Rezoning Transportation Analysis

Petition Number: 2023-092

Date	Description
9-28-23	First Review (NK)

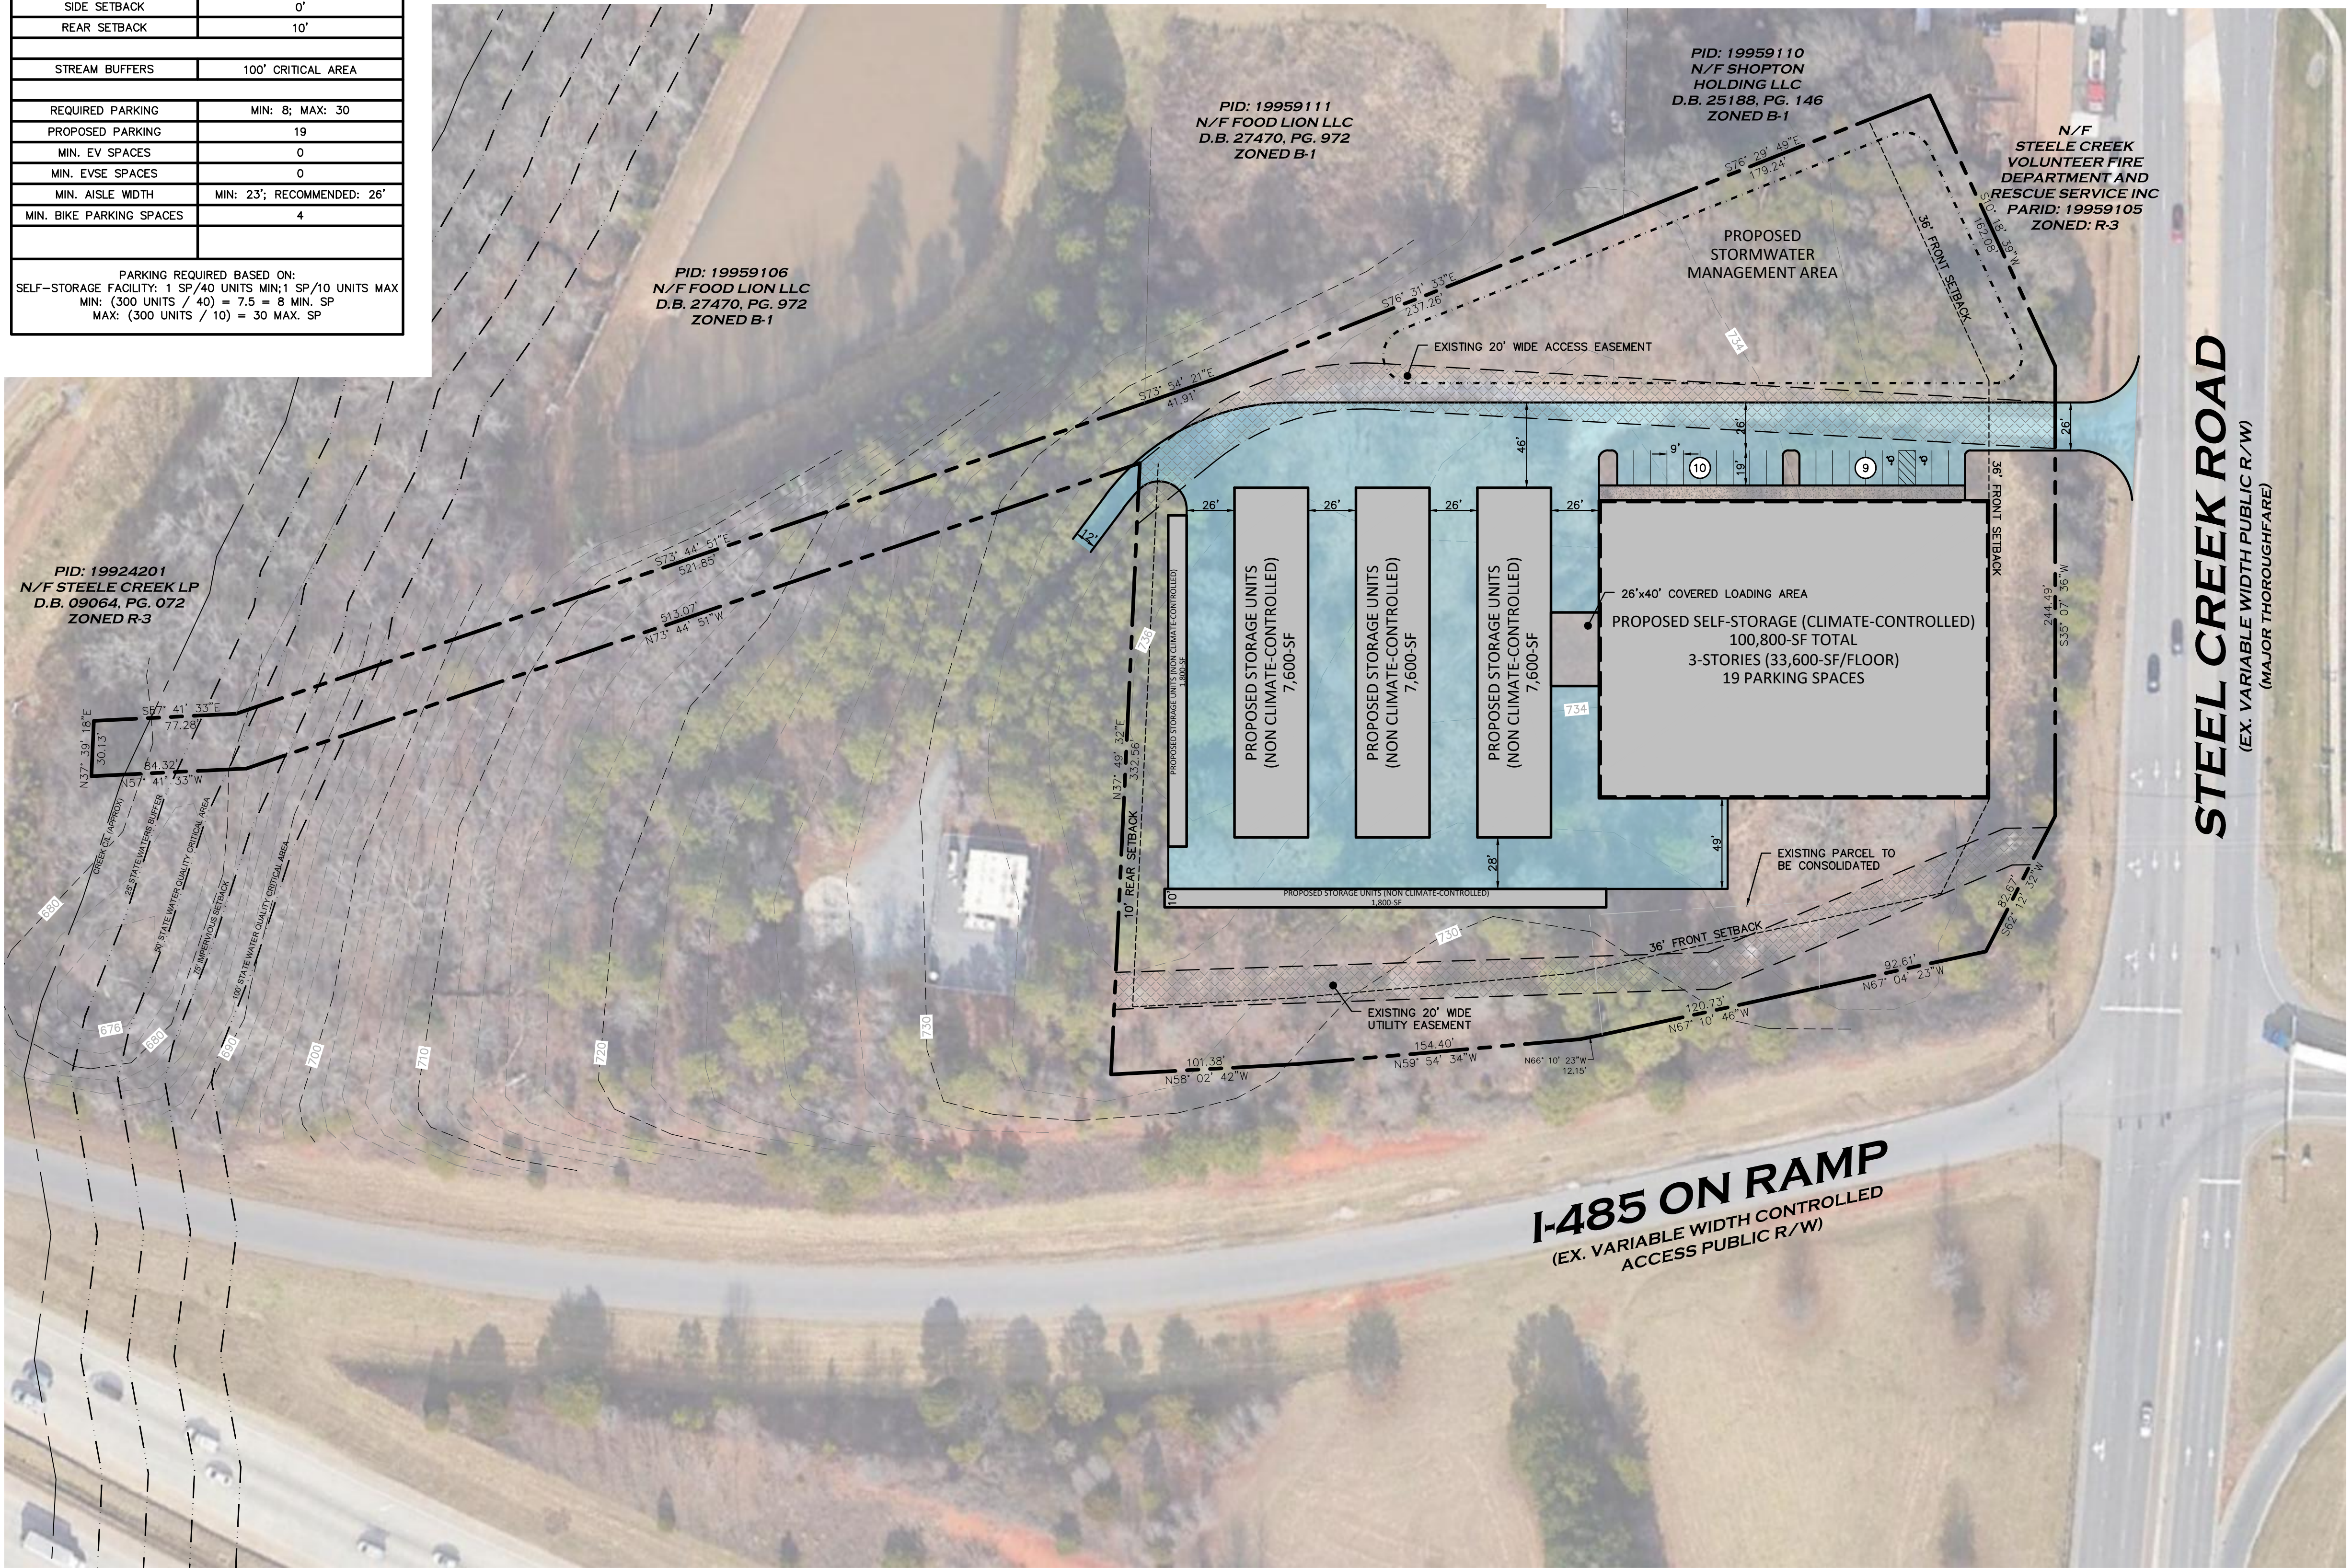
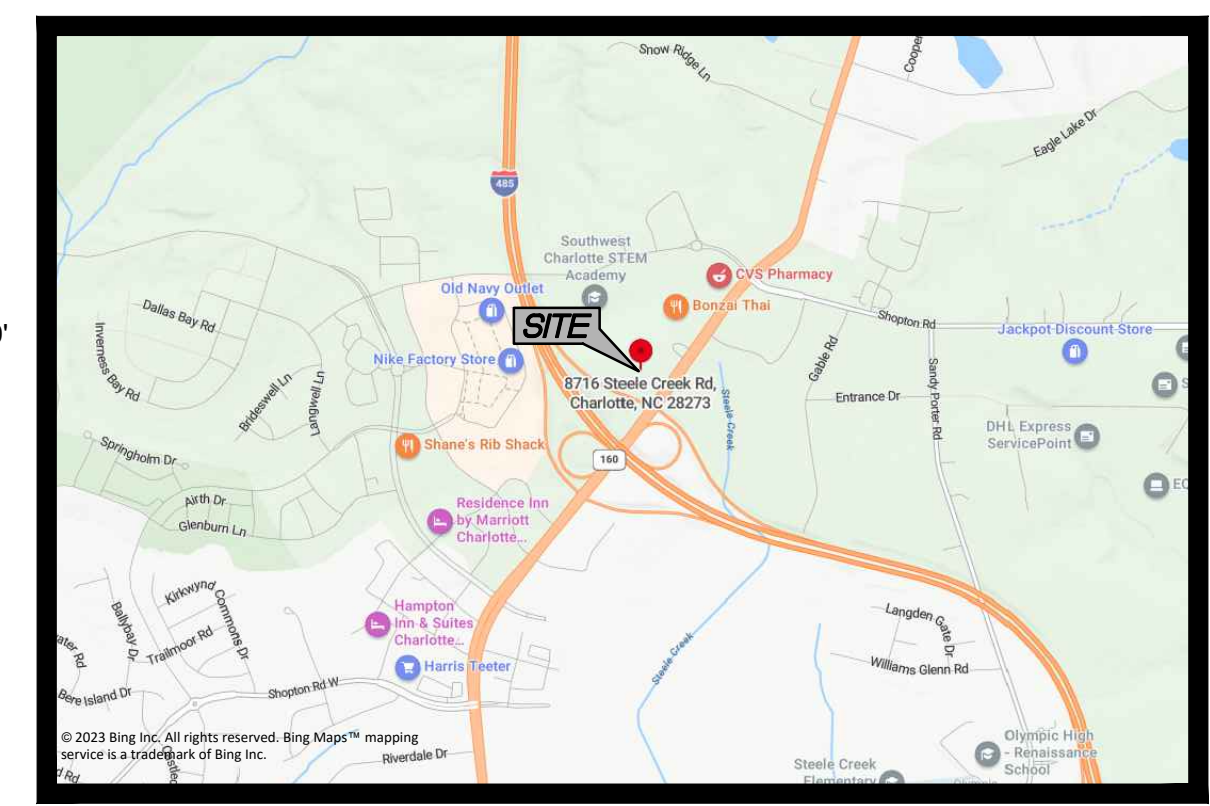
- a. **Steele Creek Road:** Location of back of curb and gutter to be moved to 41 feet from roadway centerline to accommodate the Charlotte Streets Map.

The required cross section is 4+ Boulevard, Buffered/Separated Bike Lanes

Label and dimension the curb and gutter from the centerline for each road on the site plan.

3. Revise site plan and conditional note(s) to commit to dedicate 59' right-of-way from the road centerline. The site plan shall label and dimension the right-of-way from the road centerline.

4. Revise site plan and conditional note(s) to commit to construct bicycle facilities by locating the curb and gutter 41' from the center line.
5. Add a conditional note specifying "A Right-of-Way Encroachment Agreement is required for the installation of any non-standard item(s) (irrigation systems, decorative concrete pavement, brick pavers, etc.) within a proposed/existing City-maintained street right-of-way by a private individual, group, business, or homeowner's/business association. An encroachment agreement must be approved by CDOT prior to construction/installation. Contact CDOT for additional information concerning cost, submittal, and liability insurance coverage requirements."

6. Revise site plan to commit to extending the existing median to the intersection of the I-485 ramp and Steele Creek Road in coordination with NCDOT.
7. Add a conditional note stating that any security gates must be installed 40' from the edge of pavement / beginning of the driveway in coordination with NCDOT.
